**2nd October 2000
Ref: MEC/ 217**

**Proposed amendment to Amended application
dated 30th September 000-(not yet processed)
for dwelling at 43 Knight Street,Pinchbeck for
Mr and Mrs Robert Jarvis**

Application no: H14/0805/00

DWING NO: 217/5A
 A (omit projection + gable roof over)
 (to front elevation)

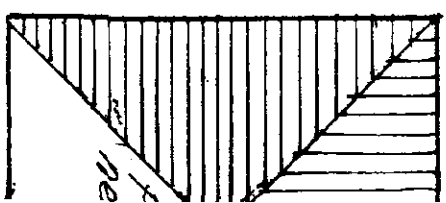
**My clients have agreed to the suggested front window design , reduced the
overall width to provide more space around the dwelling, omitted the garage
and adjusted the front walling and vehicular access. They now feel that the
central gable feature is not now necessary ,which in turn will make the central
projection pointless, and hope that you will agree to this modification as indicated
on the enclosed drawings no: 217/5A.**

Scales: 1:100 and 1:200mm. PLANS, ELEVATIONS & BLOCK PLAN. amended design Sept 26 2000. Drawing no: 217/5

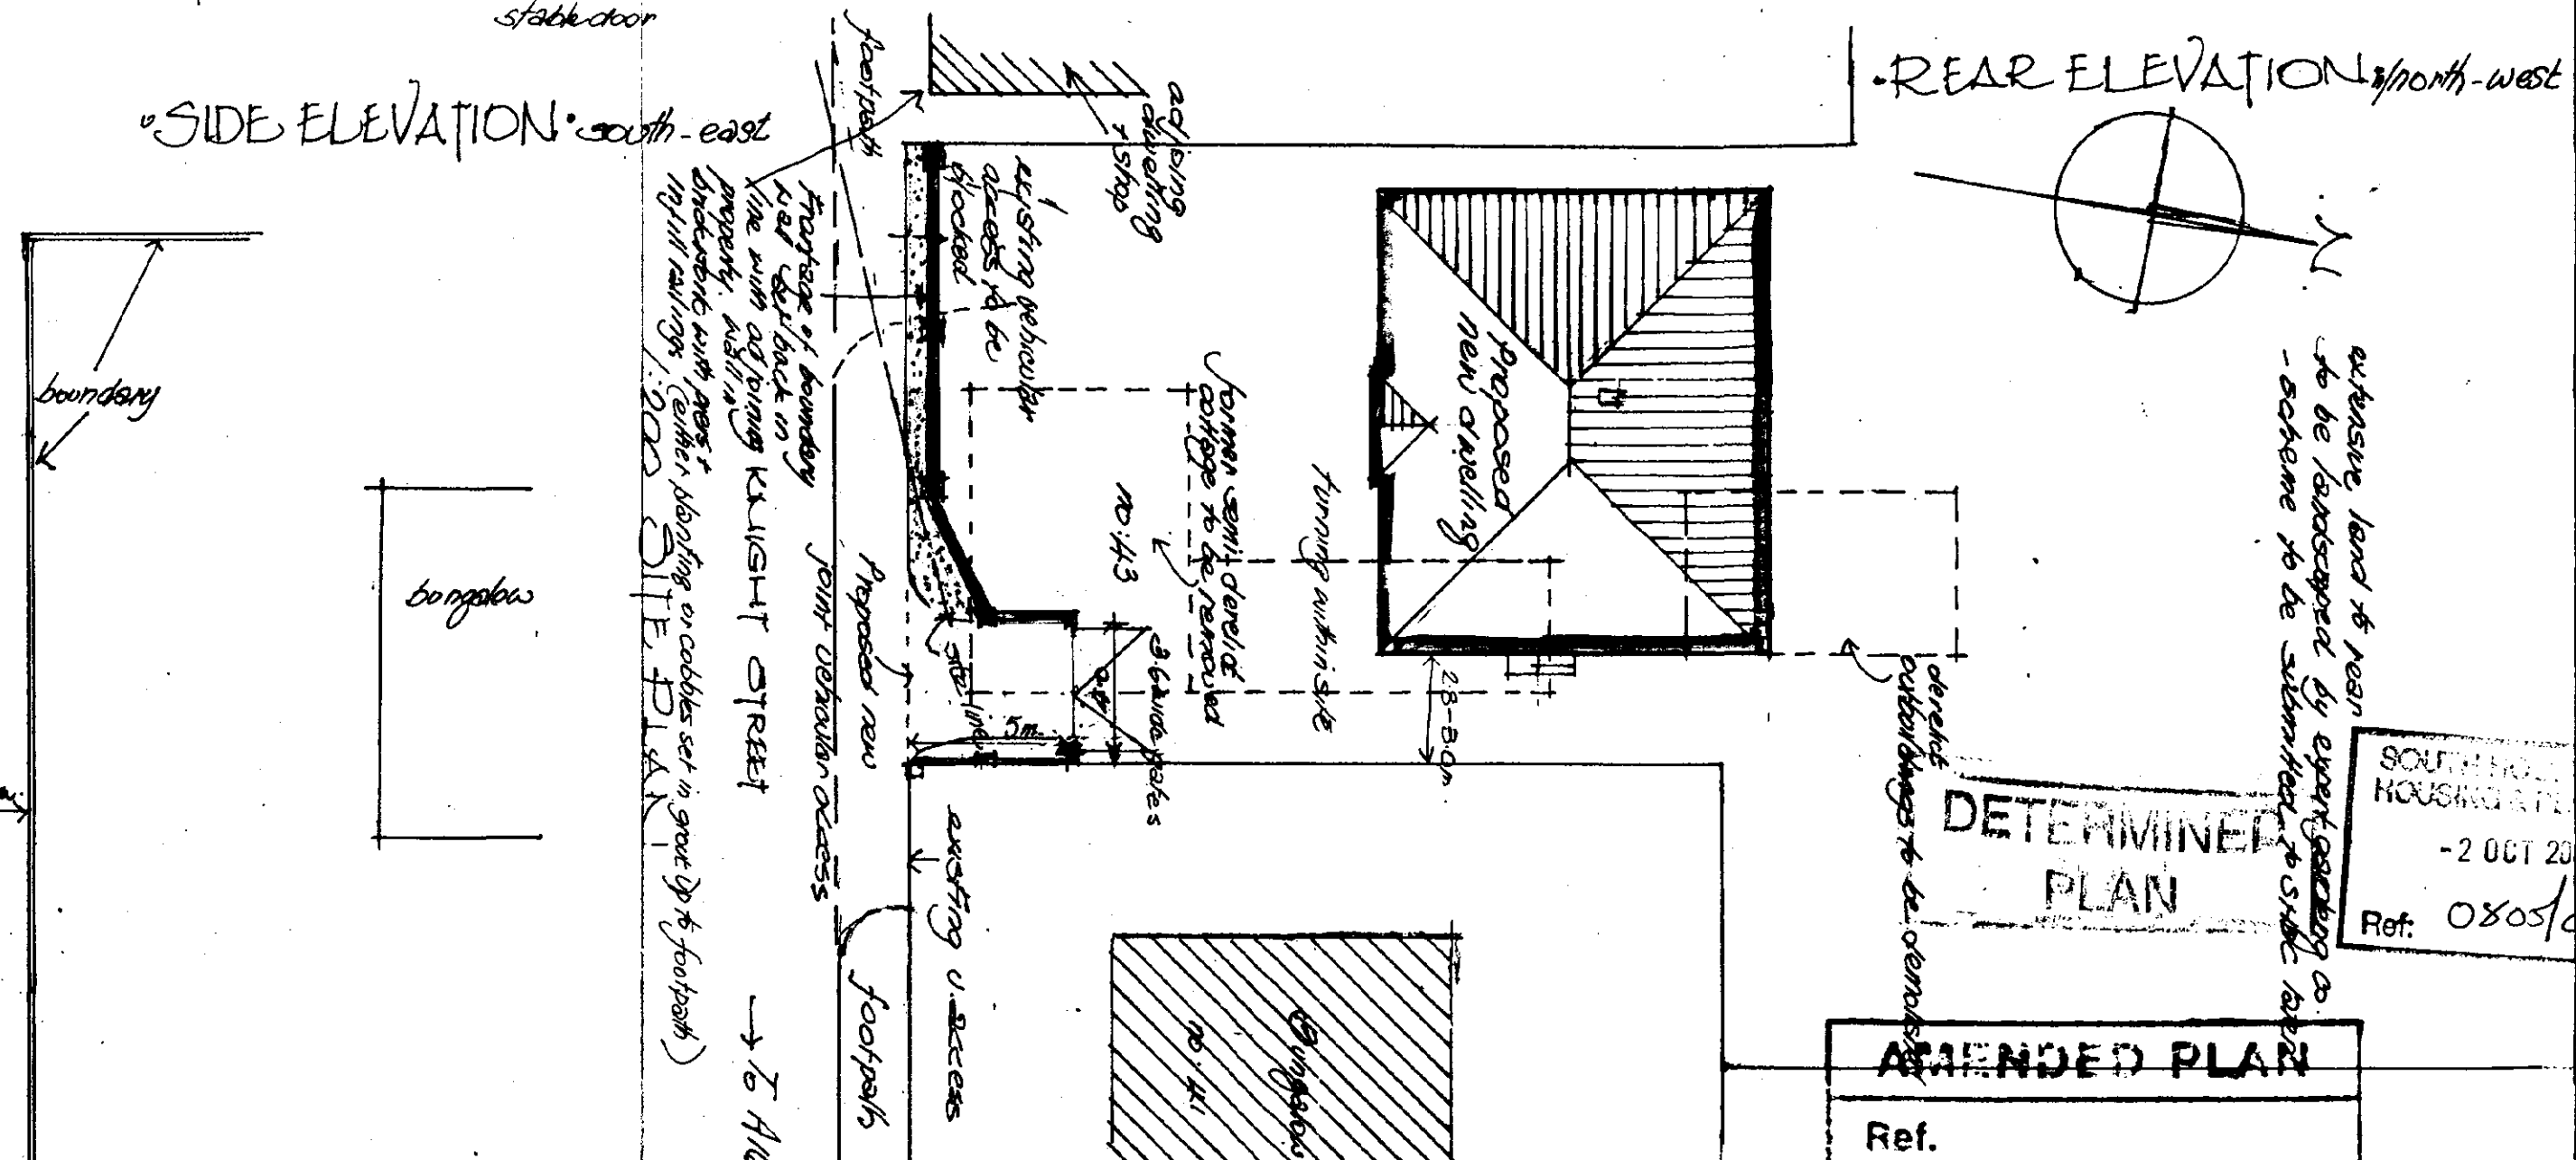
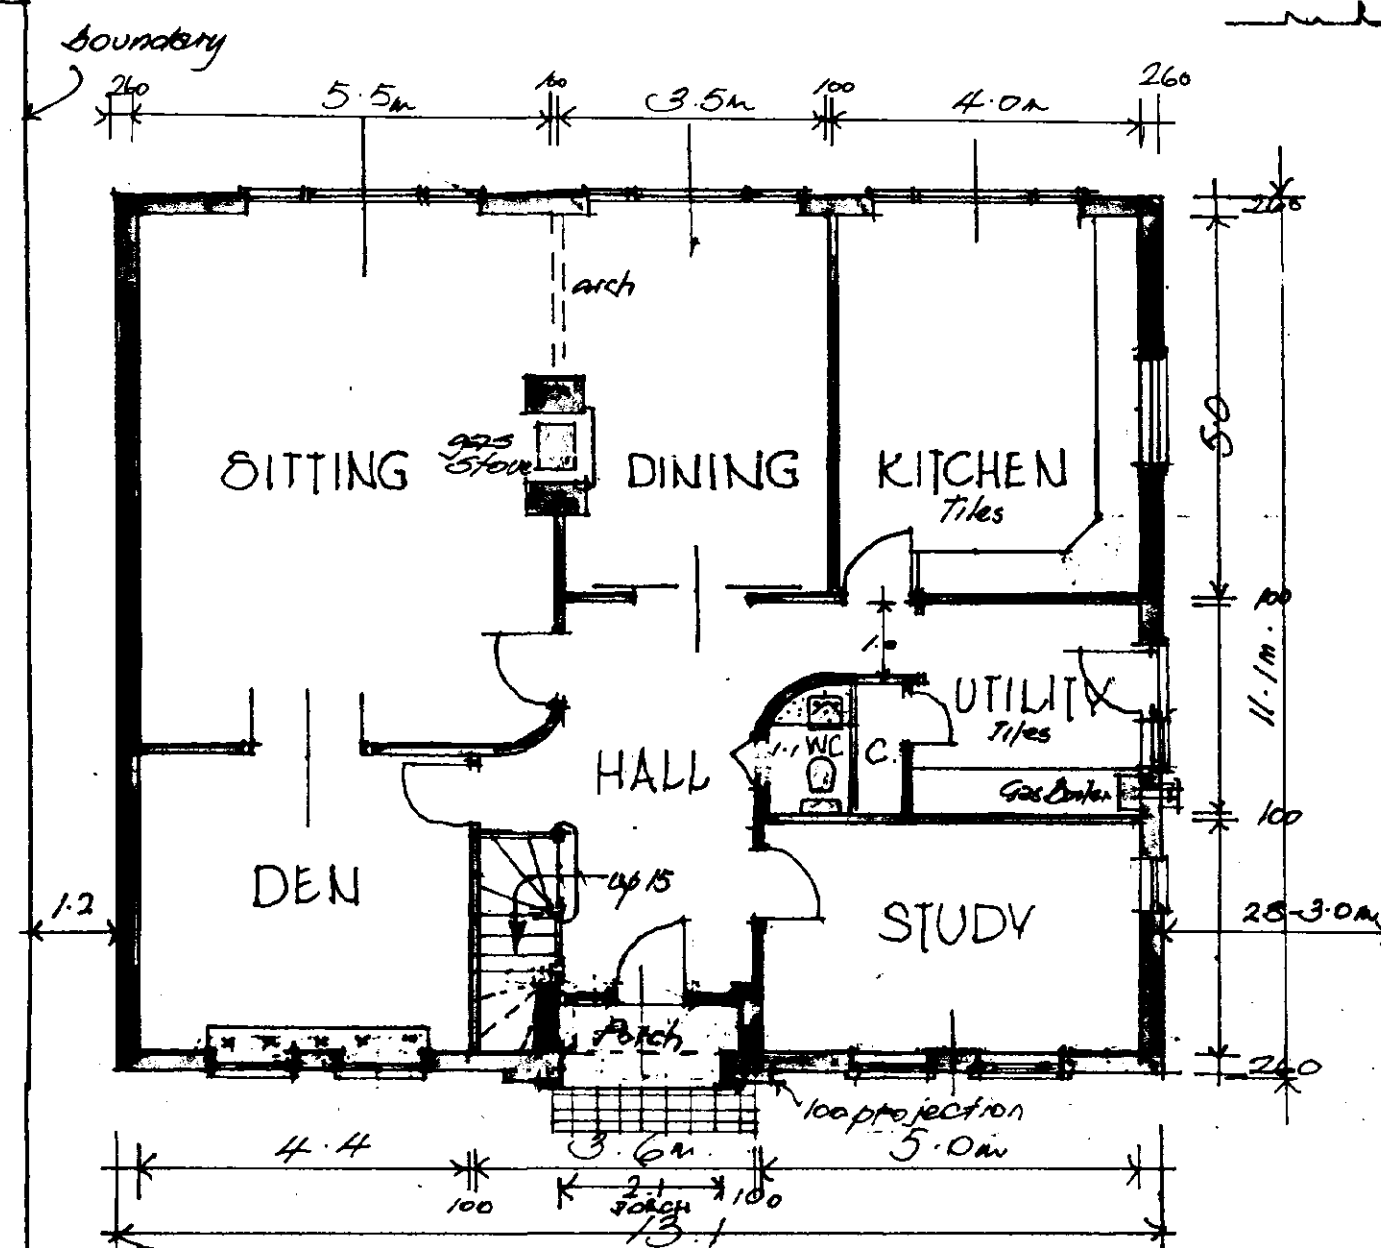
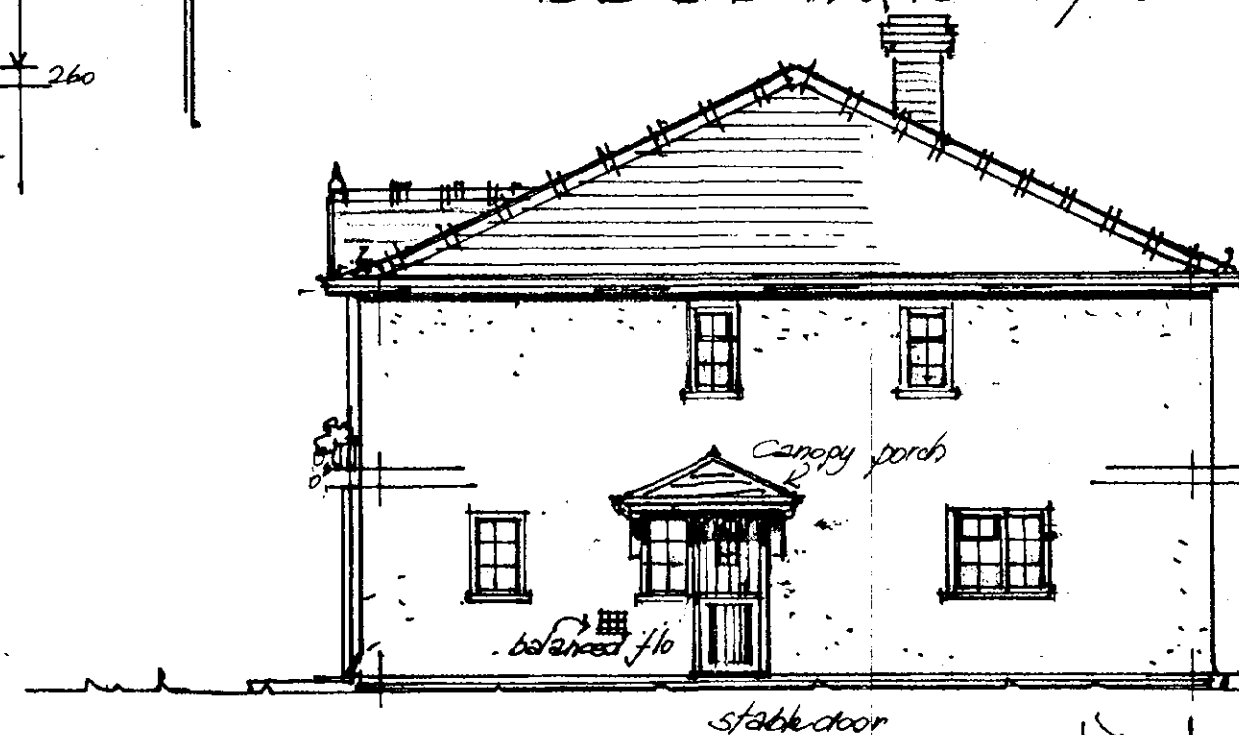
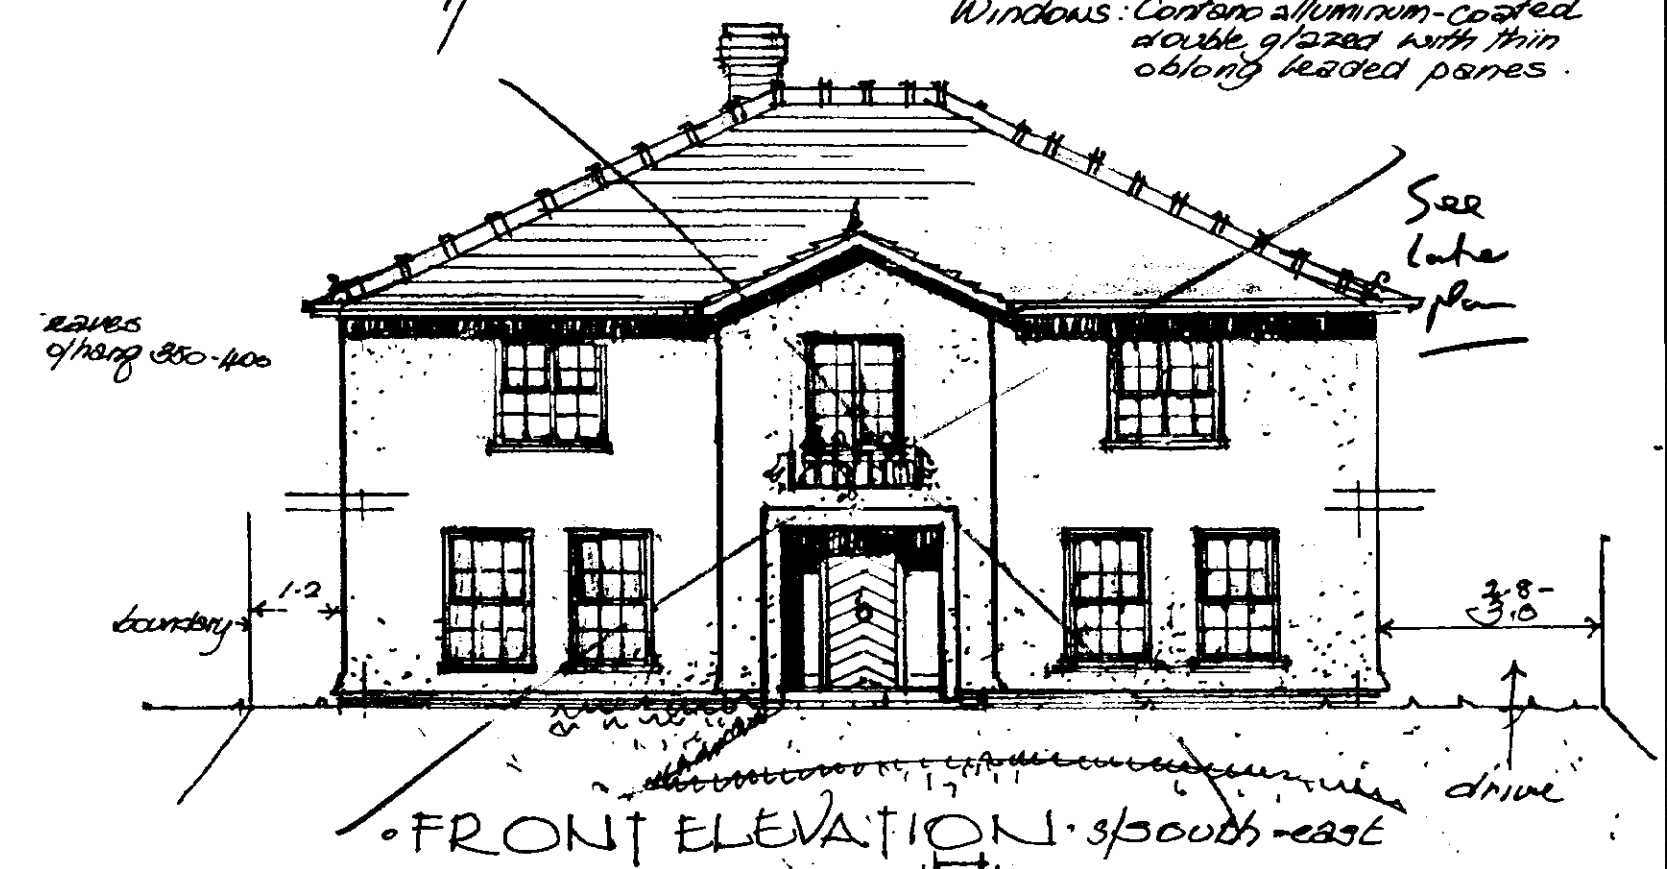
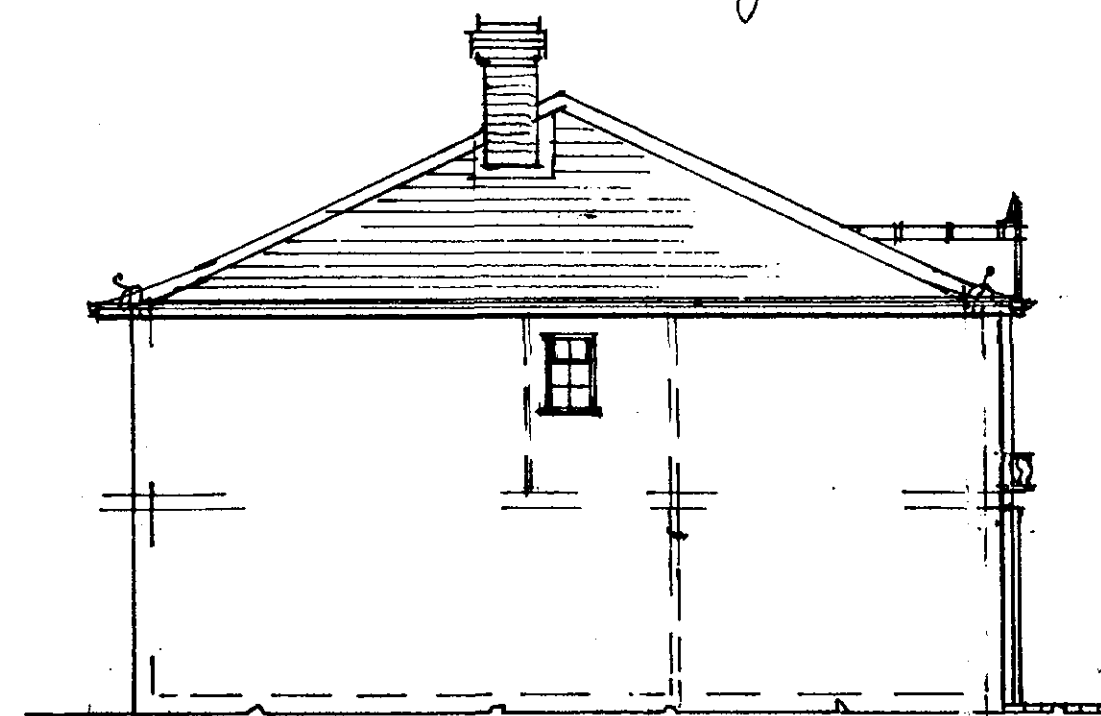
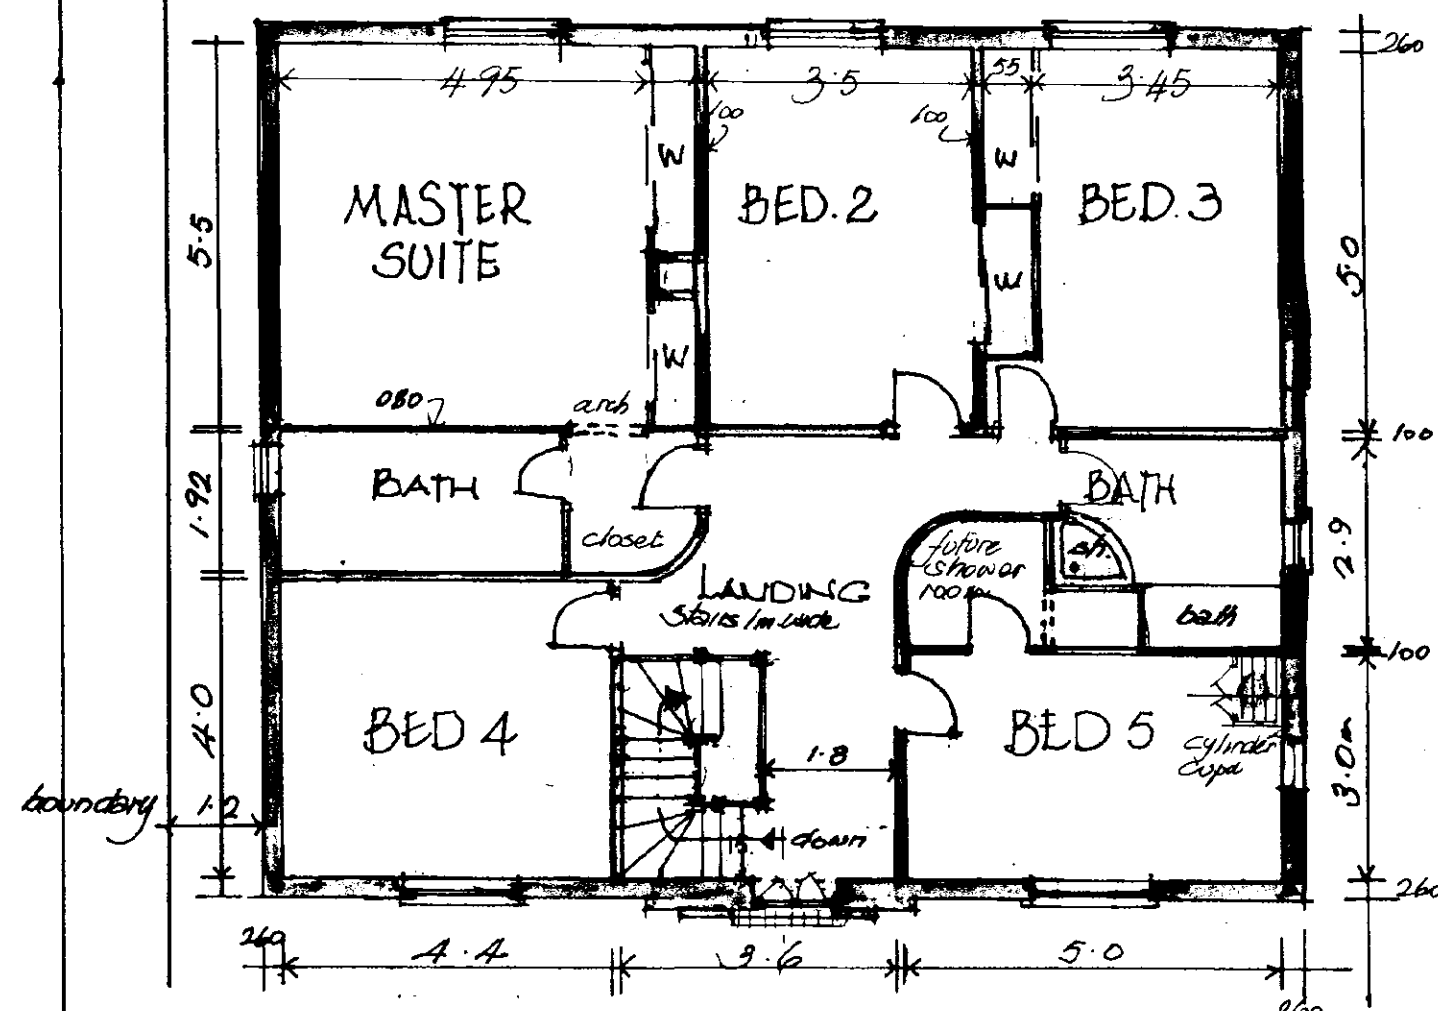
1. Size of dwelling reduced + windows amended + elevation alterations
2. Front boundary wall + railing to be set back a line with adj. shop
3. Changes to vehicular access
4. Roof pitch reduced + eaves of hang
5. Provision of access to rear by reducing width of house
